MONA OFFSHORE WIND PROJECT

Mona and Natural Resource Wales (advisory) SLVIA SoCG

Document Reference: S_D1_14 F02

14 January 2024

Figure 1.54: Figure A1 of Volume 7, Annex 6.4: Landscape, seascape and visual impact assessment methodology (APP-156).

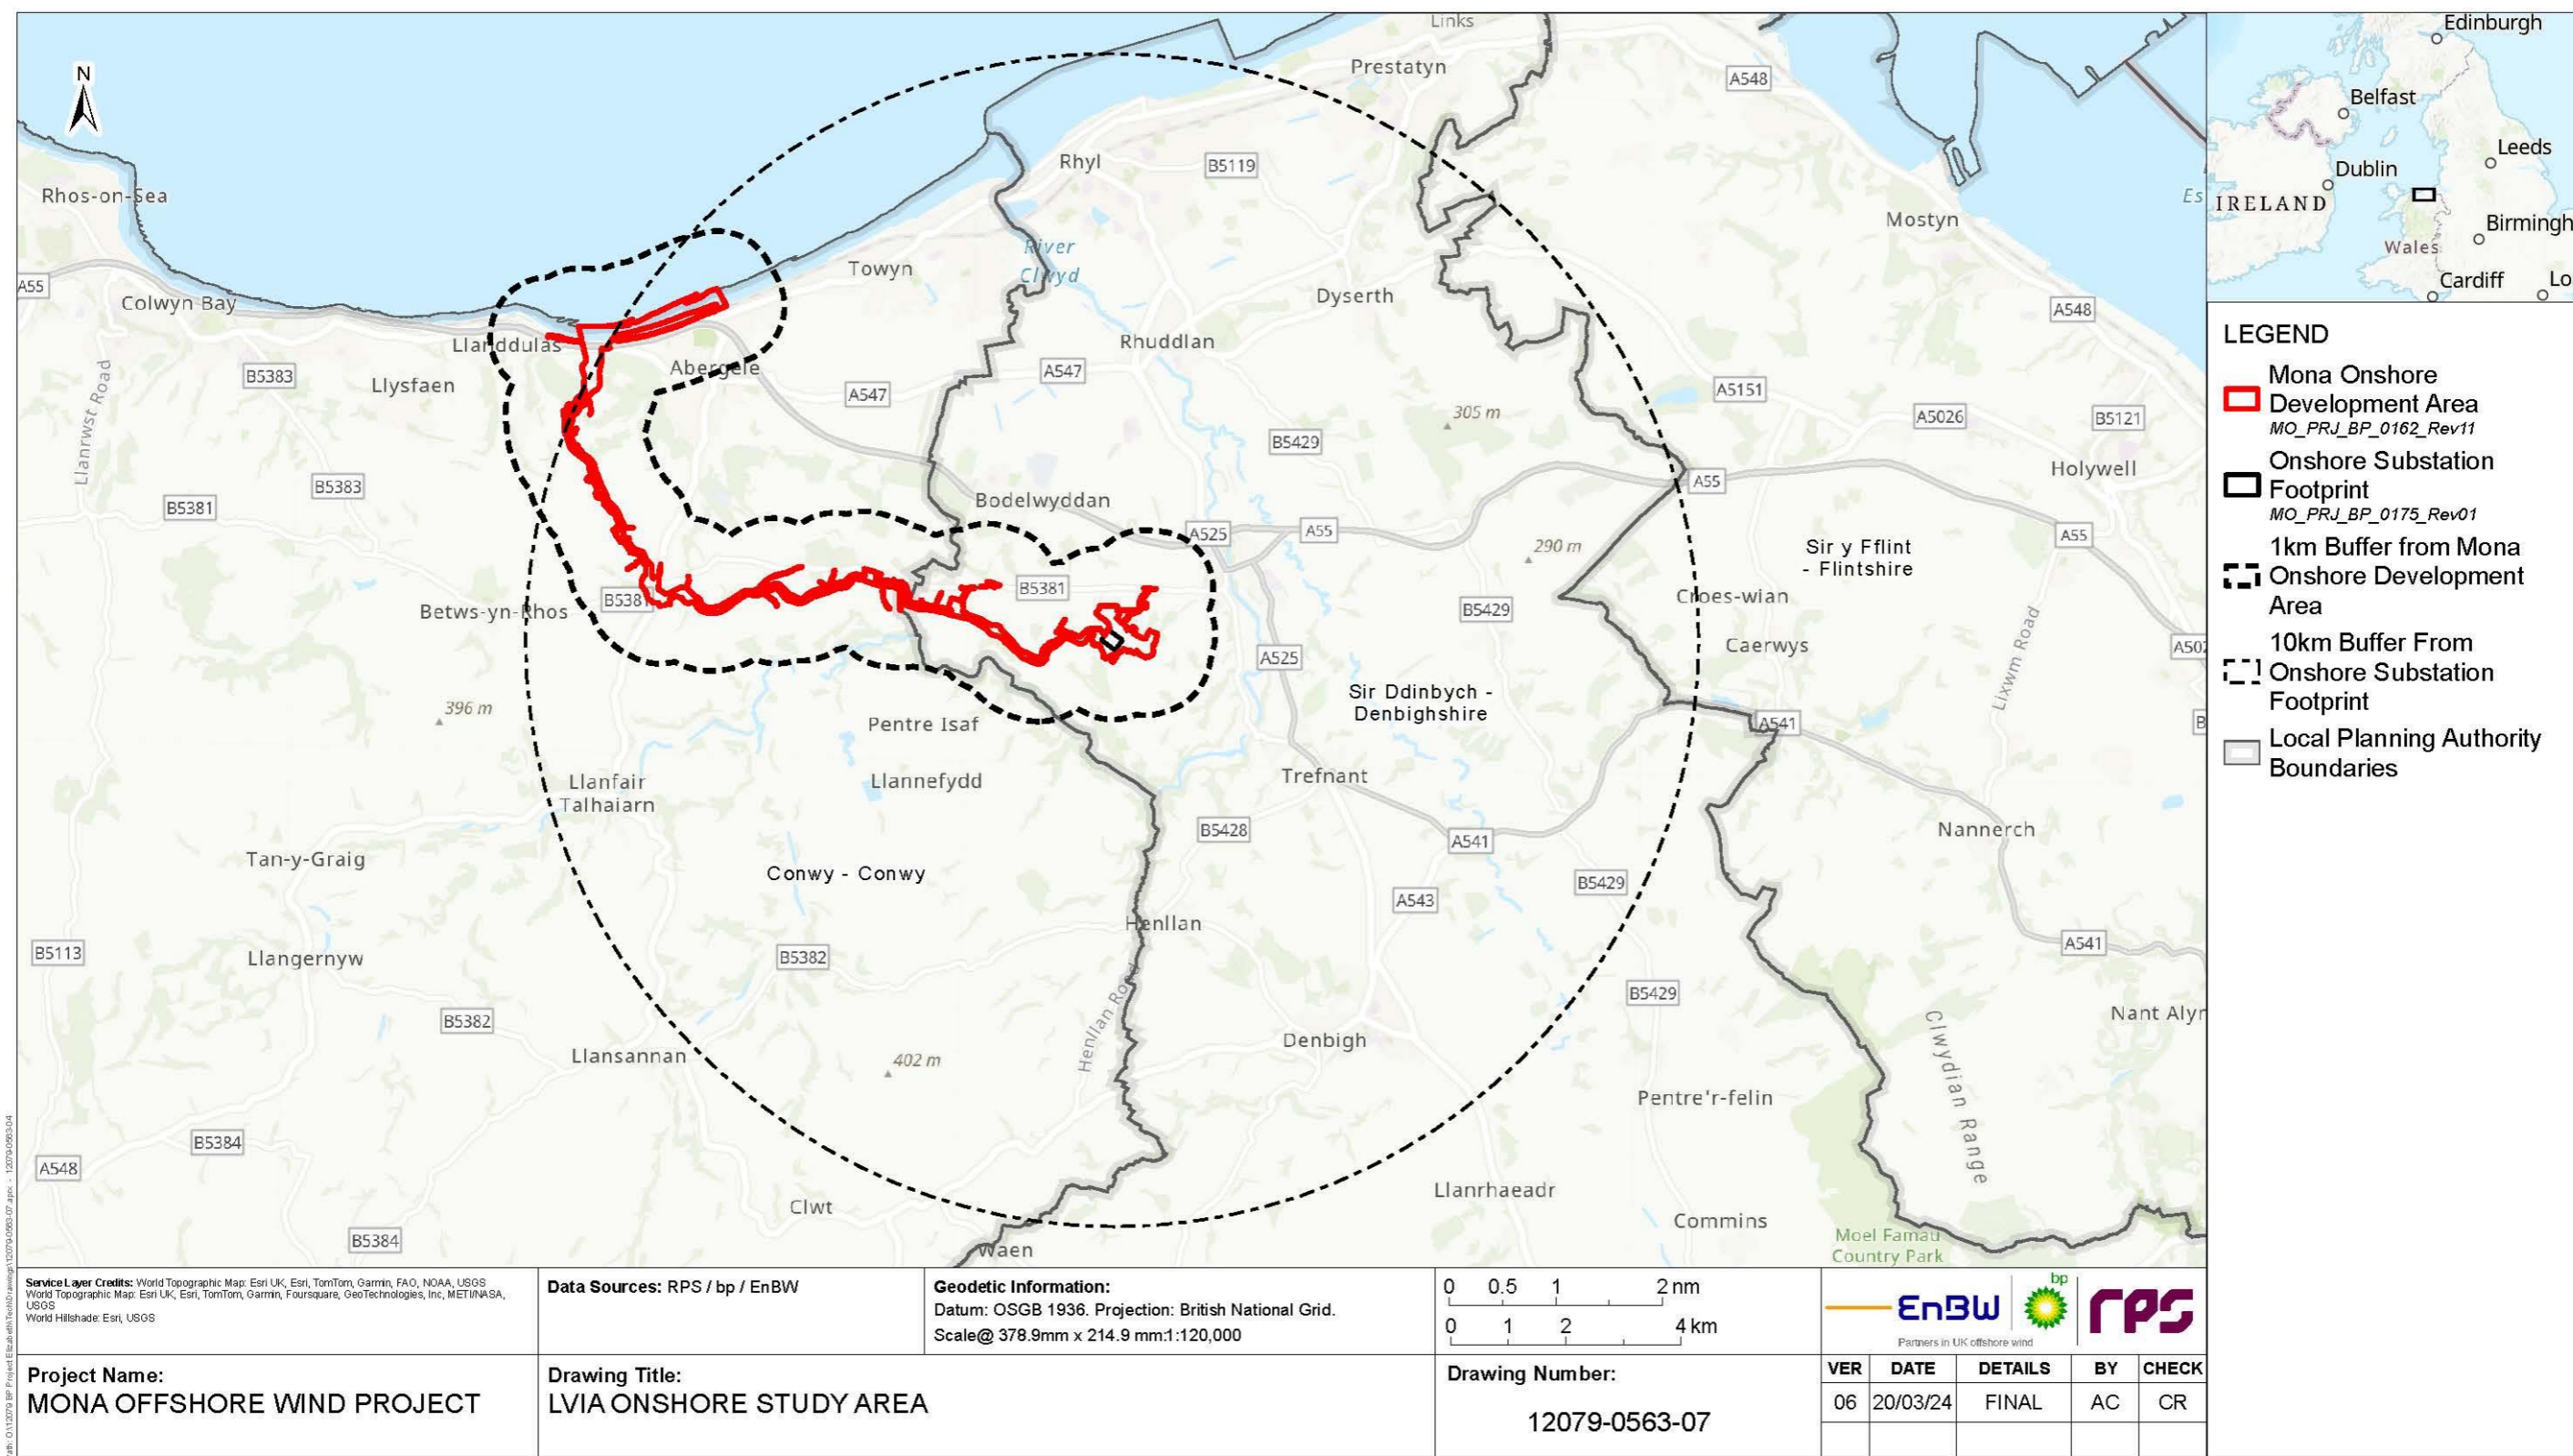
Reference Number	Discussion point	Applicant's Position	NRW (A)'s Position	Status
EIA				
NRW.SVR.1	Consultation	The Applicant has undertaken adequate consultation with NRW (A) on potential impacts on seascape and visual resources.	NRW (A) agrees that the Applicant has undertaken adequate consultation with NRW (A) on potential impacts on seascape and visual resources.	Agreed
NRW.SVR.2a	Consultation	The EIA has had due regard to matters raised by NRW (A) through statutory and non-statutory consultation on potential impacts on seascape and visual resources. The Applicant has provided an assessment of local landscape and seascape character in Landscape and Seascape Character in Wales – assessment of effects from the Mona Array Area (REP4-087).	NRW (A) welcomes the provision of the additional assessment, although we do not agree with the findings.	Agreed
NRW.SVR.2b	Consultation	The EIA has had due regard to matters raised by NRW (A) through statutory and non-statutory consultation on the presentation of information, including presentation of information. The Applicant notes NRW (A)'s response at deadline 3 (paragraph 164) and provided NRW (A) with the Zone of Theoretical Visibility (ZTV) on a 1:50,000 OS base (REP4-046). The Applicant notes NRW (A)'s response within this SoCG and provided NRW (A) with the cumulative ZTV on a 1:50,000 OS base at Deadline 6.	NRW (A) welcomes the provision of the ZTV mapping on a 1:50:000 OS base which replaces the previous mapping presented at 1:1,000,000 (Figure A.4) and the cumulative ZTVs which were presented at approximately 1:200,000.	Agreed
